Sturton by Stow Parish Council

Cumulative Impacts Assessments

Draft Consent Order

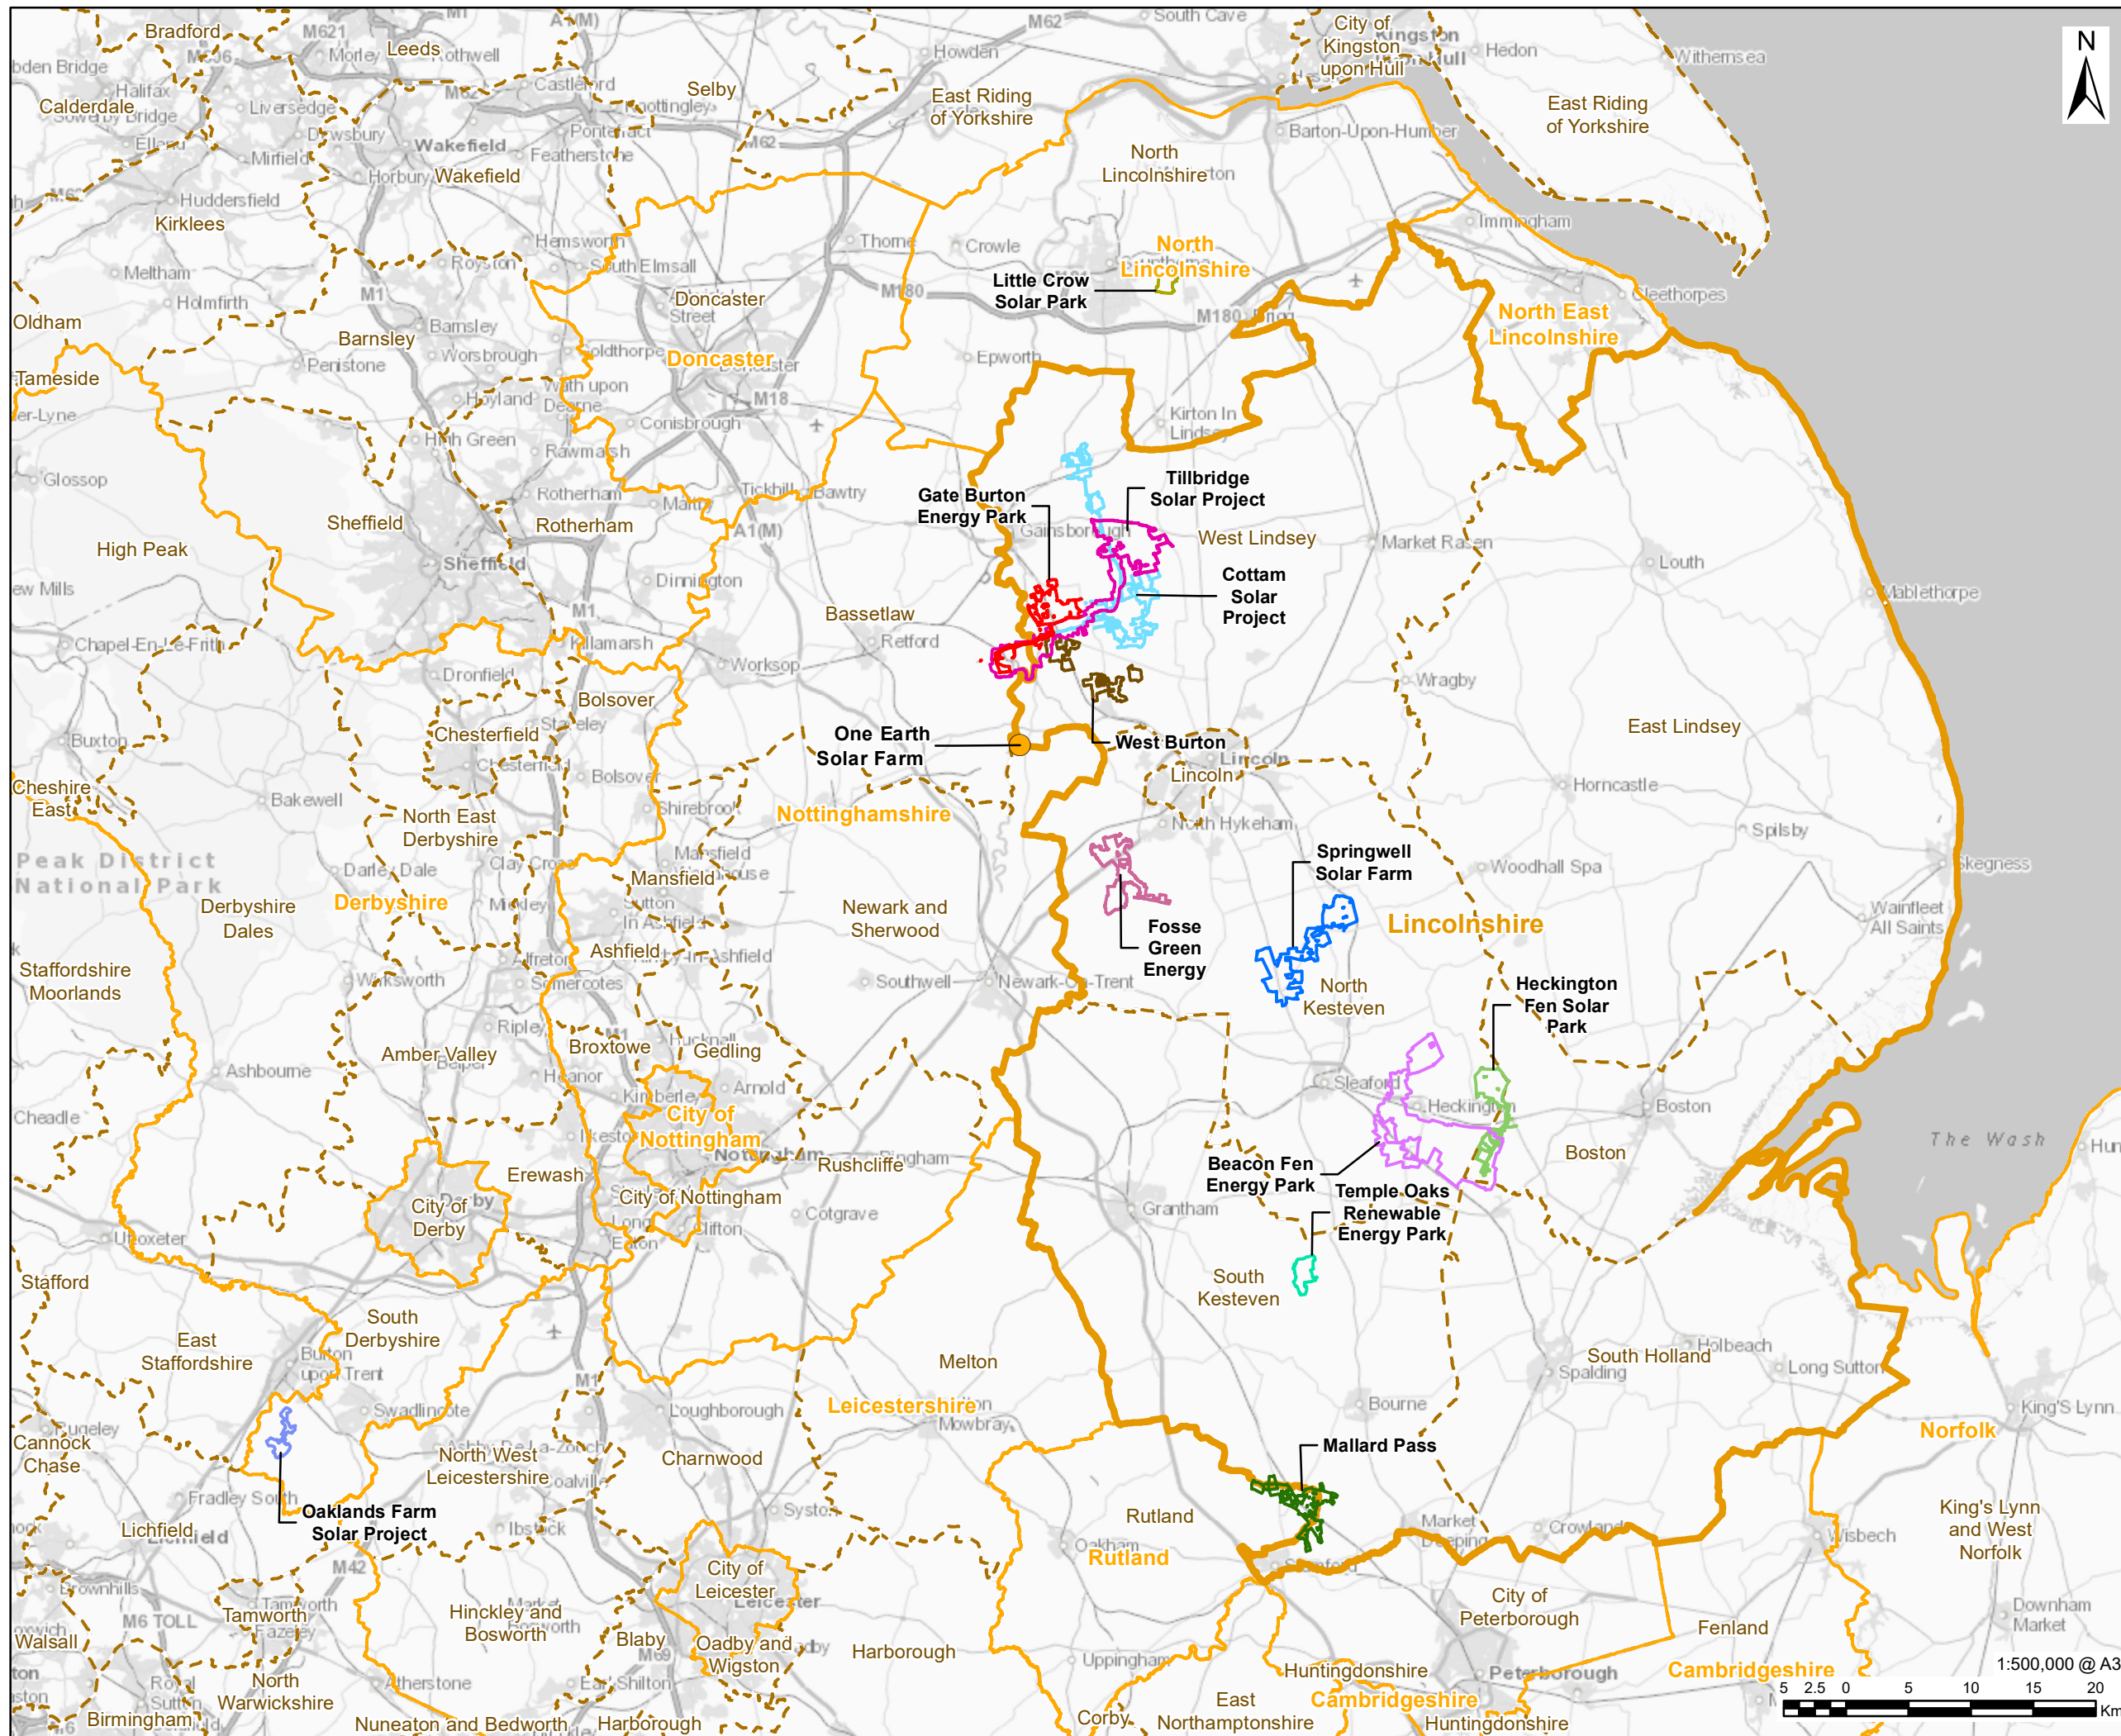
There are at least two more solar sites not listed in documentation and are in the immediate vicinity.

Stow Park (Luminous Energy) sited between Sturton by Stow parish – Westwoods and Marton.

One Earth Project which has just been announced – Sept.2023 - and is projected to be sited south of Dunham Bridge (A57) – each side of River Trent.

Stow Park (Luminous Energy) and One Earth Solar should also to be shown on a cumulative assessment map for clarity.
